**KIRKLEES METROPOLITAN COUNCIL
INVESTMENT & REGENERATION SERVICE**

**DELEGATED DECISION FOR DISCHARGE OF CONDITION A.4 -
NOTIFICATION OF A PROPOSED ENLARGEMENT TO DWELLINGHOUSE**

Reference no.	2022/HH/92024/E
Site Address	19, Howard Street, Batley, WF17 6AA
Description	The proposal is for erection of single storey rear extension. The extension projects 6m beyond the rear wall of the original dwellinghouse. The maximum height of the extension is 4m, the height of the eaves of the extension is 3.7m
Recommending Officer	Alice Downham

DECISION - REFUSED

REAR ELEVATION

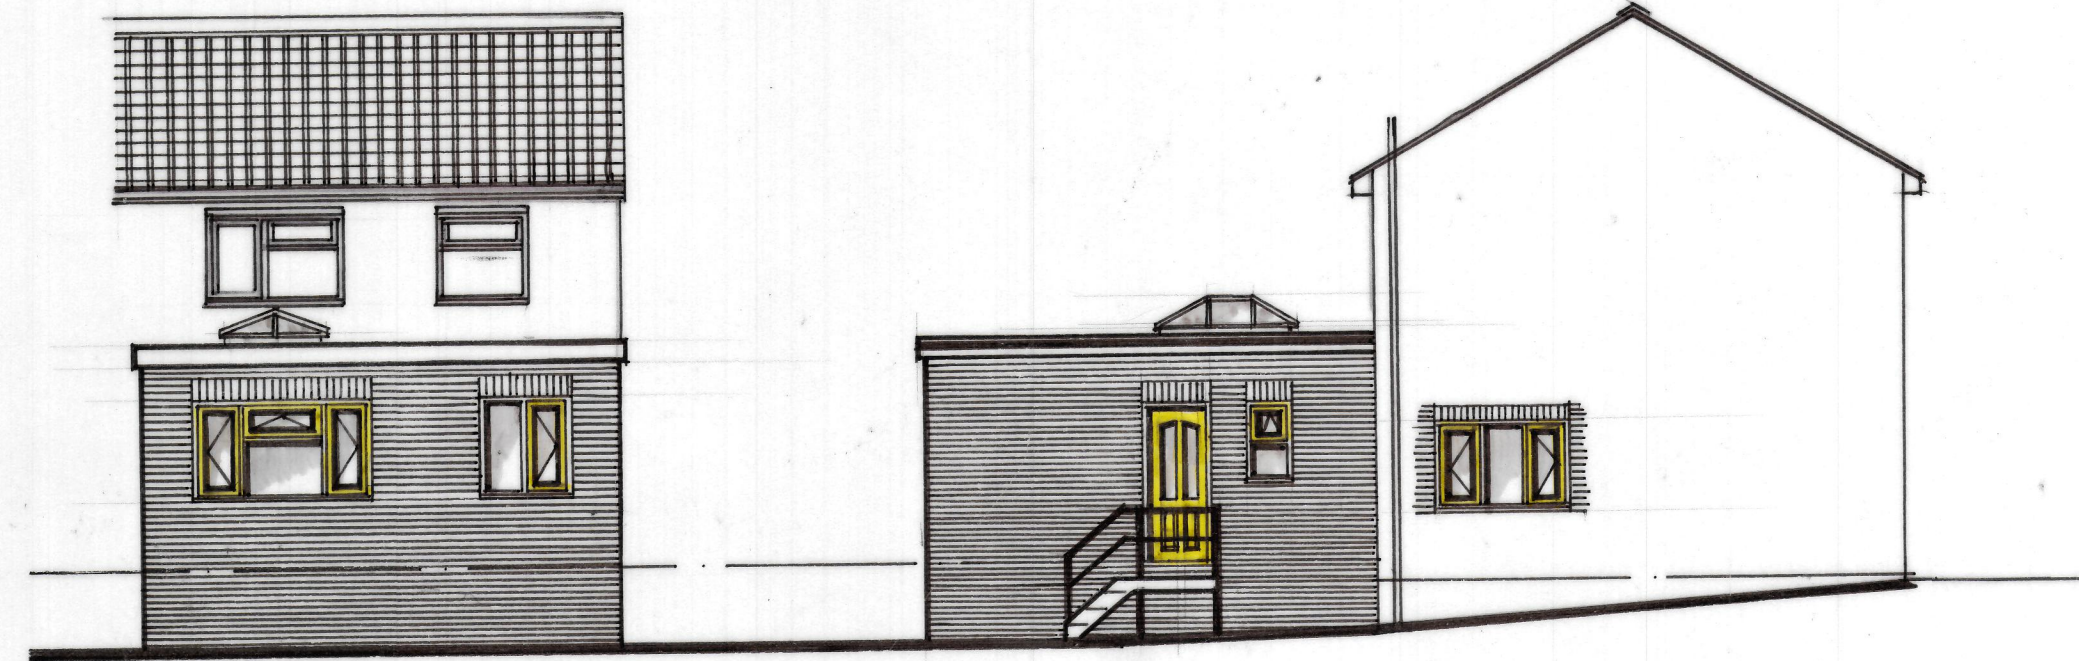
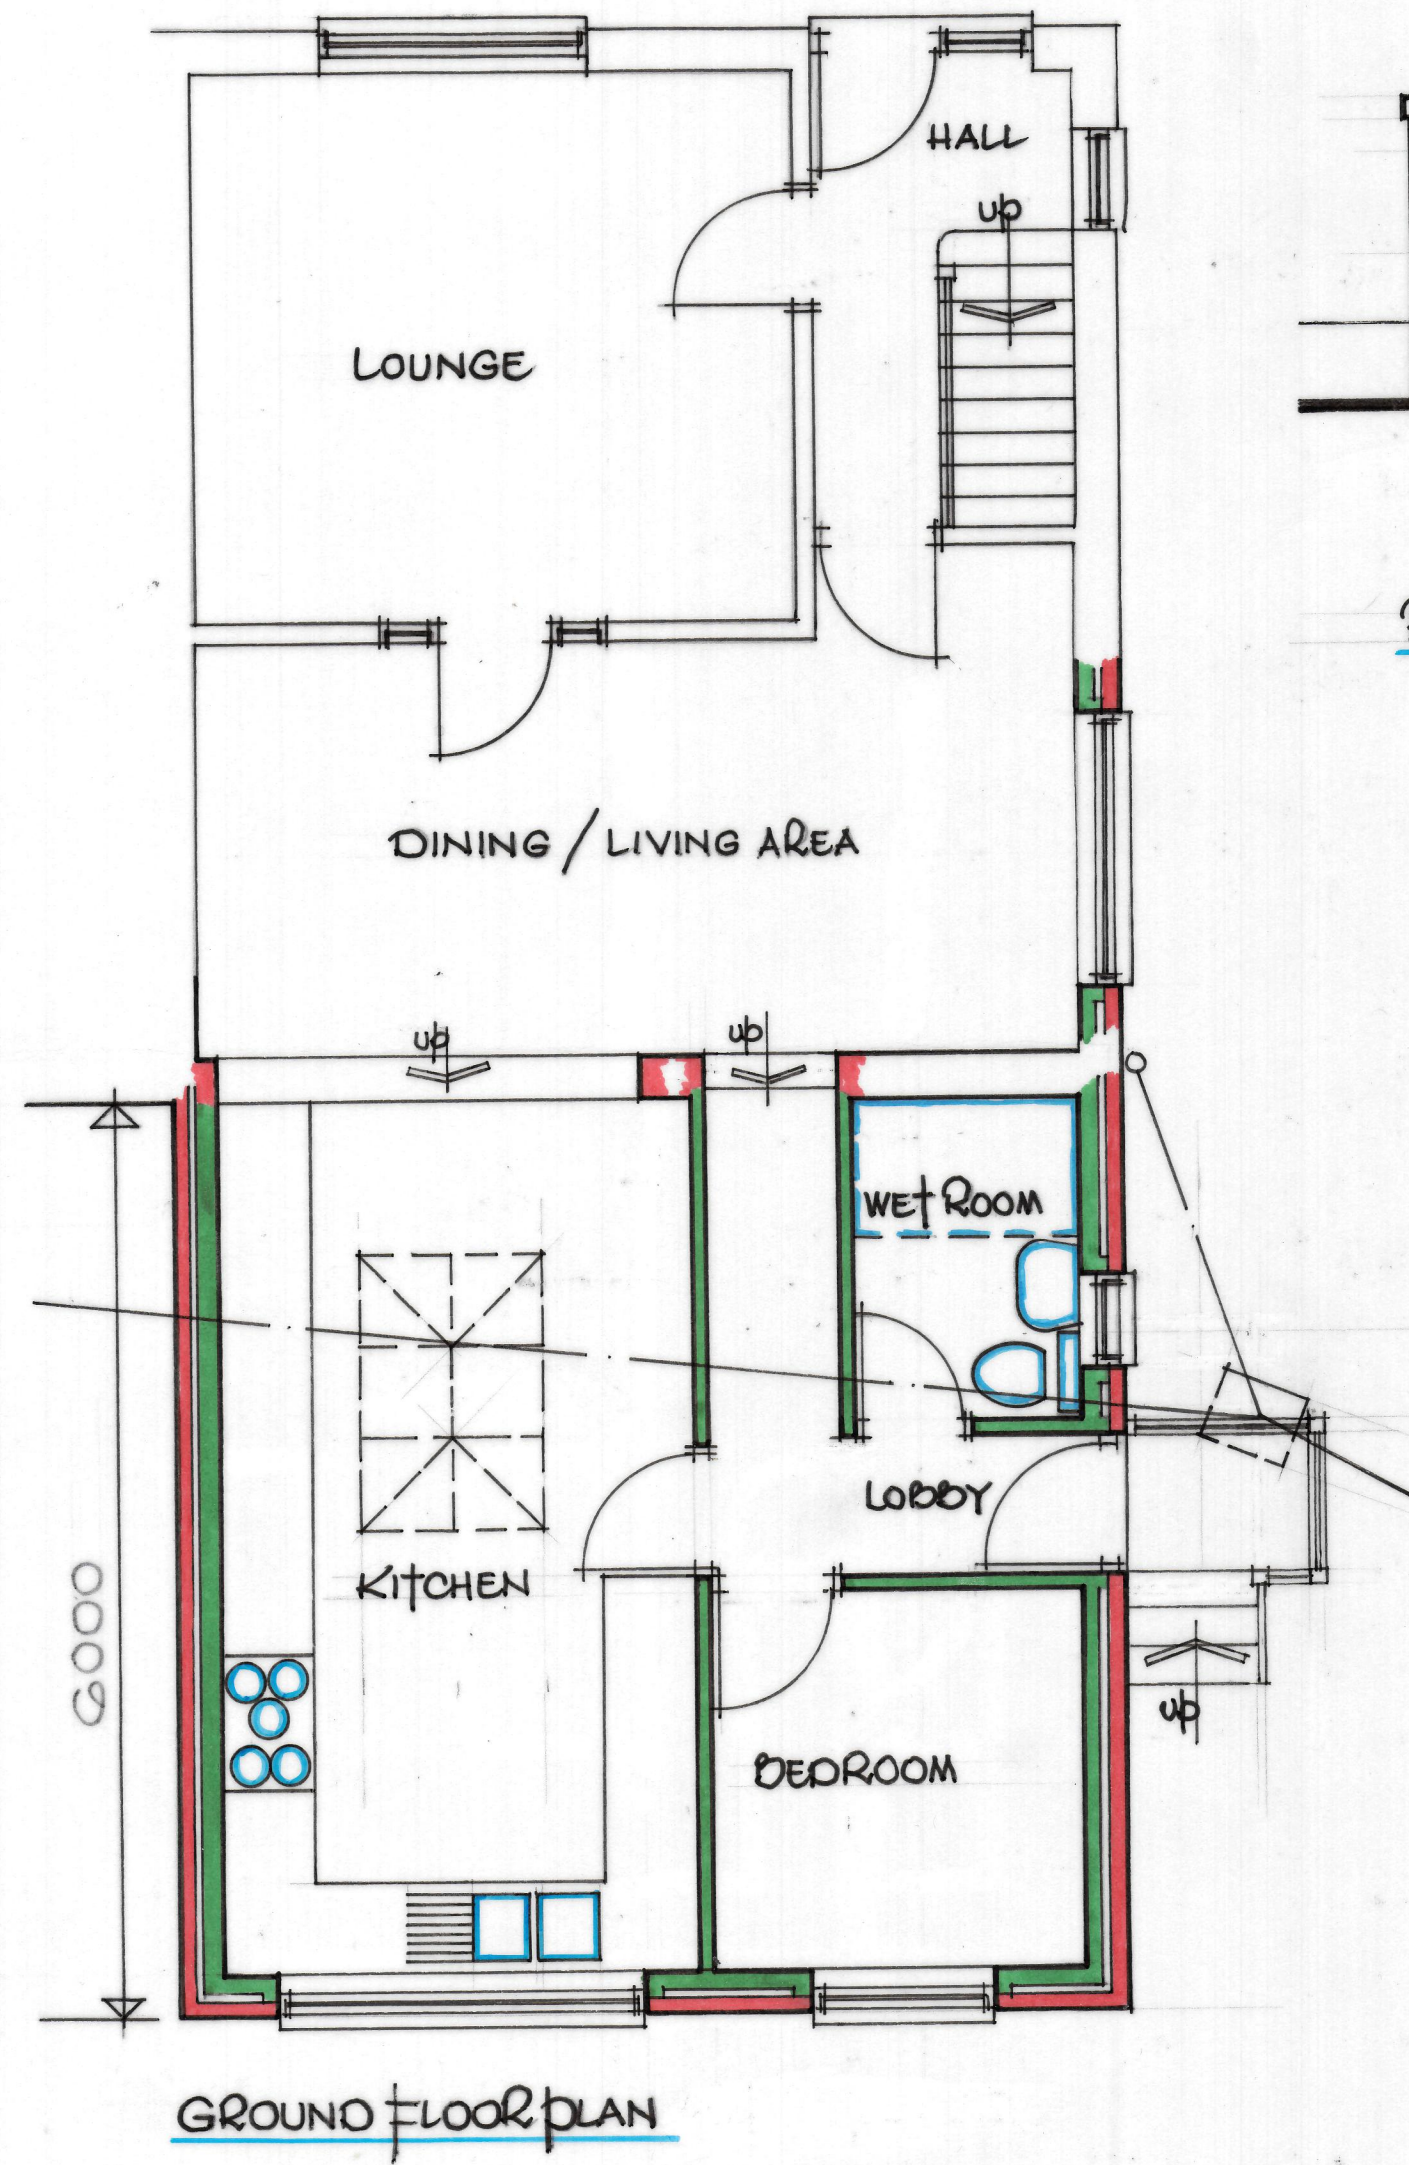
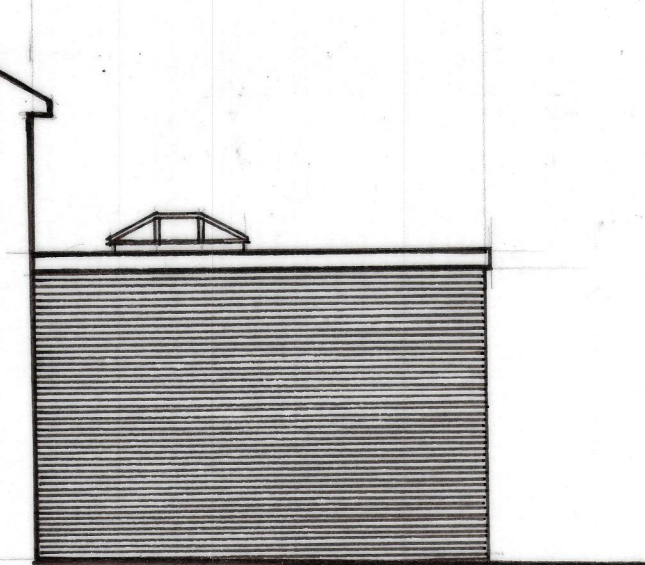
The application states on the application form that the eaves height would be 3.7m above natural ground level. The submitted plans indicate a drop in land levels from the front of the property to the rear thus increasing the height of the proposed extension. The submitted plans confirm the eaves height is 3.7m and that also the proposed extension is sited along the common boundary with the adjoining property. Given the height of the eaves and proximity within 2m of the curtilage boundary the proposed extension exceeds the criterion in sub-paragraph (i) of Class A, Part 1 of Schedule 2 of the Town and Country Planning (General Permitted Development)(England) Order 2015(as amended) which states development is not permitted if *"the enlarged part of the dwellinghouse would be within 2 metres of the boundary of the curtilage of the dwellinghouse, and the height of the eaves of the enlarged part would exceed 3 metres"*. As such and by virtue of sub-paragraph (3) of paragraph A.4 of the same Order the Local Planning Authority may refuse the application.

The proposed extension is considered not to benefit from a general planning permission under Article 3(1) and Class A, Part 1 of Schedule 2 of the Town and Country Planning (General Permitted Development)(England) Order 2015 (as amended) as the height of the eaves and proximity to the boundary is contrary to sub-paragraph (i) of Class A.
